Our Ref: **EP/85/11/TC**
Your Ref:

Various tree surgery within the Station Road, East Preston Conservation Area
South Eastern Corner of Church and grounds St Mary's Church Station Road/Vicarage Lane
East Preston

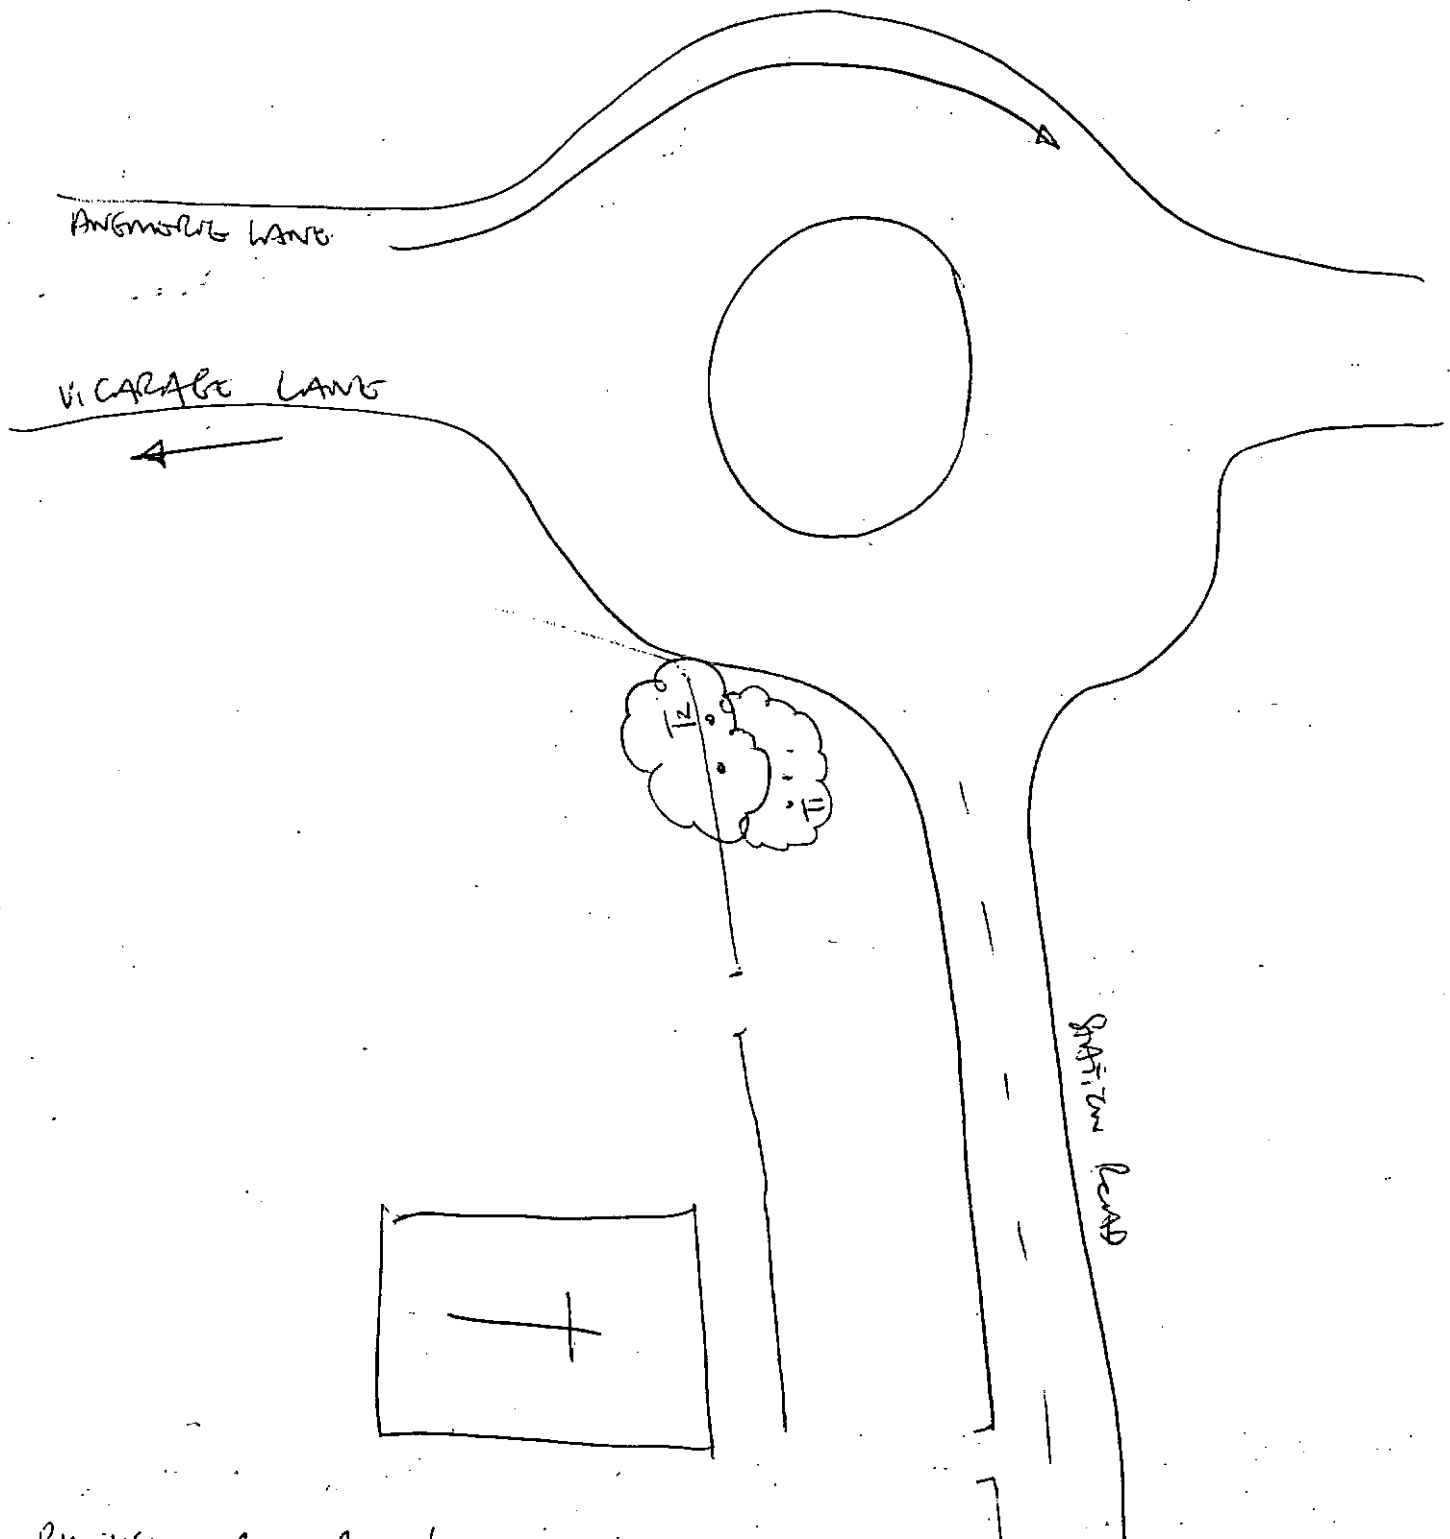
Please clarify T1; is it 2 separate trees (one being an 'Euronymus' and the other a 'Bramble') or one tree, being an 'Euronymus'.

Please confirm the percentage of canopy lift to the Bay tree.
